CITY OF ALBUQUERQUE

**Re: Lot 21-A Block 2 Unit 19 Volcano Cliffs, S.A.D. 228
7704 Compass Dr. NW
Request Permanent C.O. – Accepted
Engineer's Stamp Dated: 12-10-2019 (D10D003G21A)
Pad Certification dated: 1/14/2020
CO Certification dated: No Date
Revised Certification dated: 9/15/2020**

**Re: Lot 21-A Block 2 Unit 19 Volcano Cliffs, S.A.D. 228
7704 Compass Dr. NW
Request for Permanent C.O. – Not Accepted
Engineer's Stamp Dated: 12-10-2020 (D10D003G21A)
Pad Certification dated: 1/14/2019
CO Certification dated: No Date**

Based on the Certification received 9/11/2020, this site cannot be accepted for release of Certificate of Occupancy by Hydrology until the following comments are addressed.

TYPE OF APPROVAL/ACCEPTANCE SOUGHT:

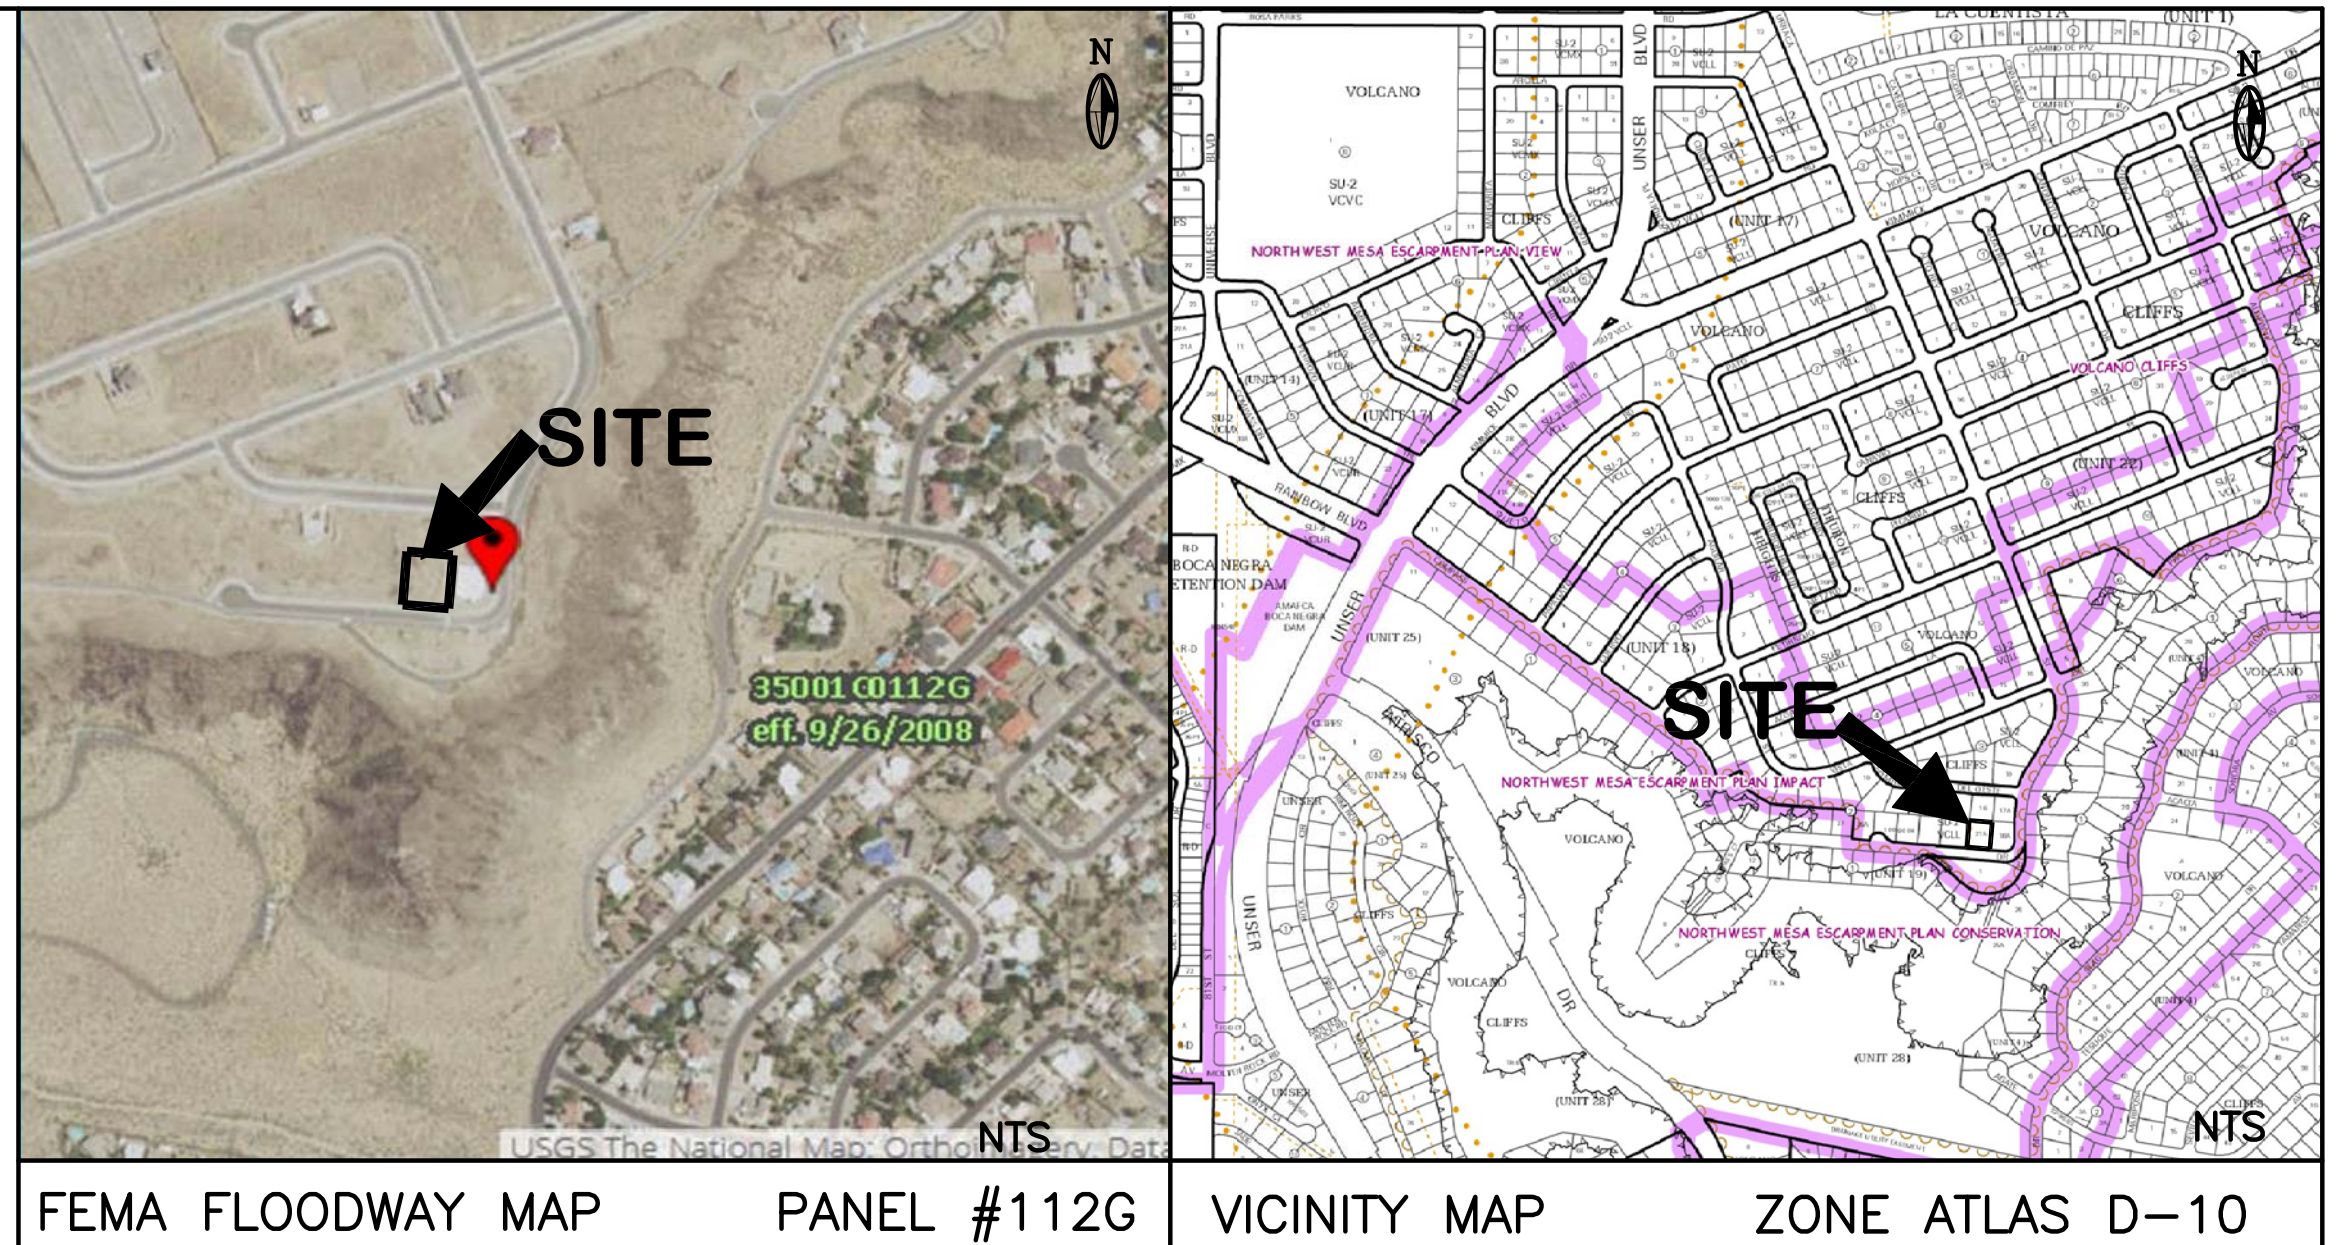
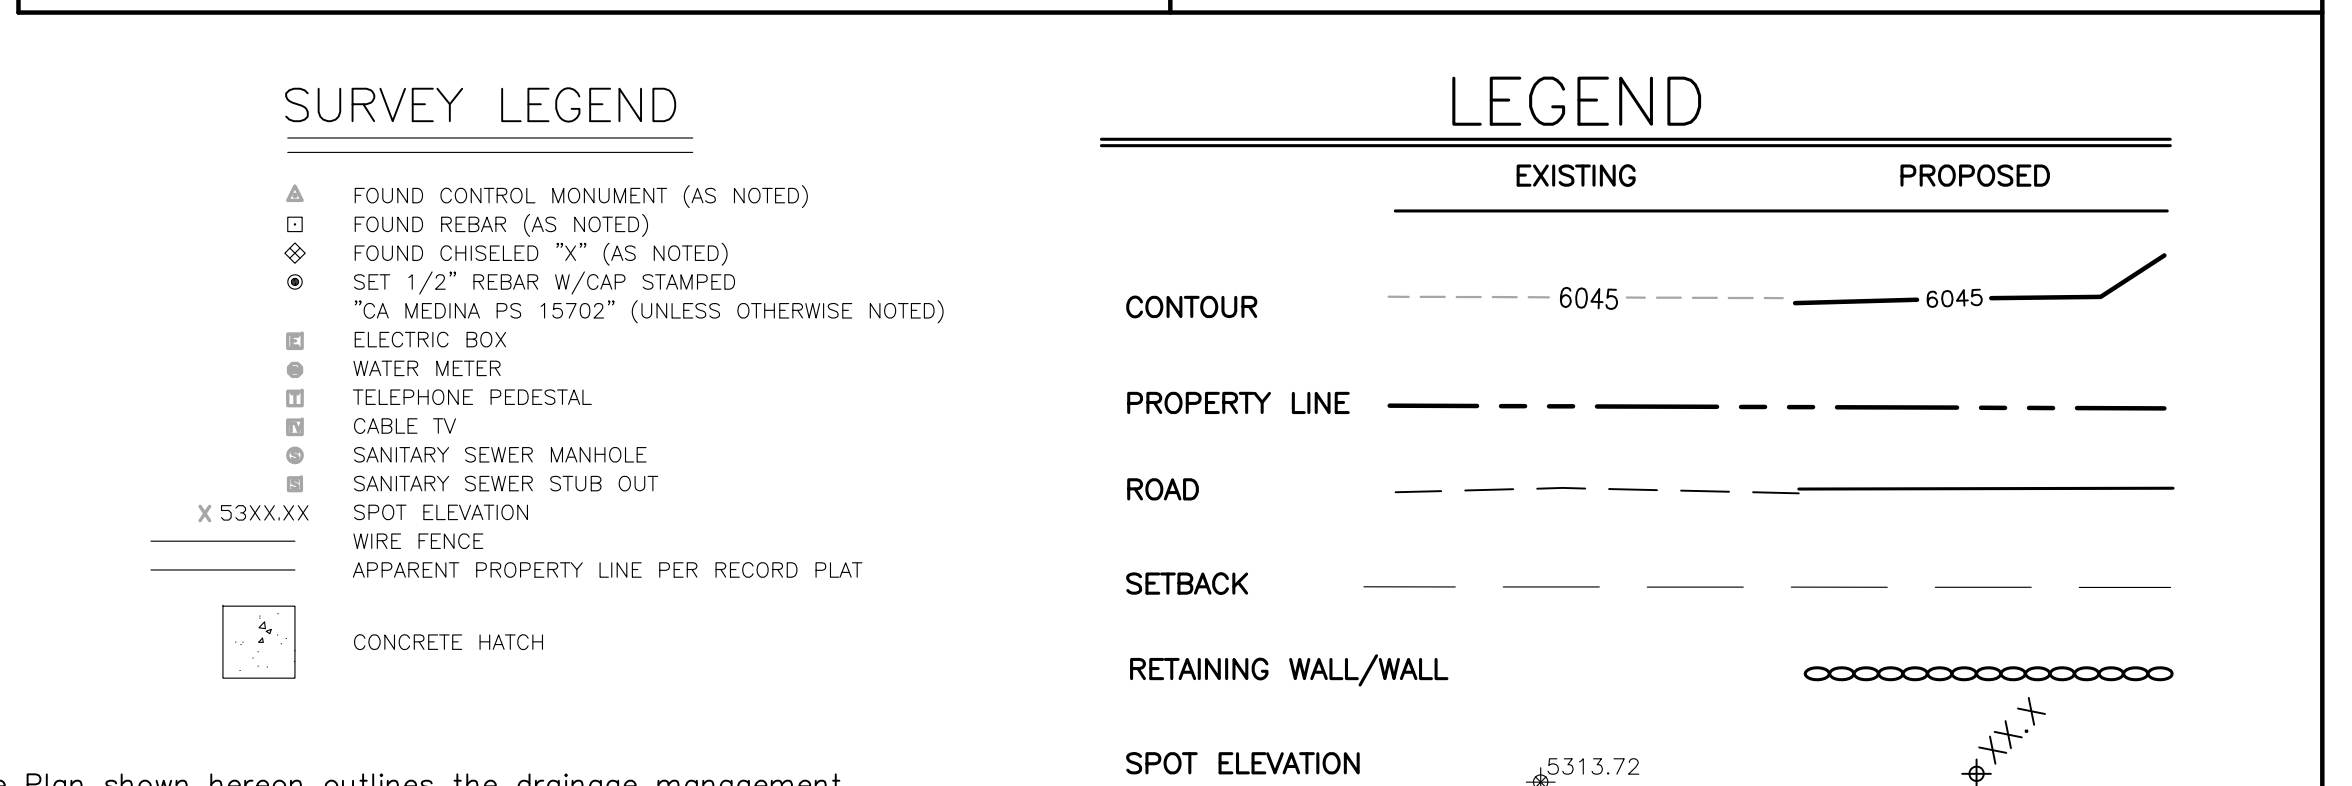
- Provide a signature and date for the CO. **added**
- Provide landscaping for ponds and swales. **added**
- Provide the drive pad. **added note that the driveway material will be gravel - per discussions with the owner and you**
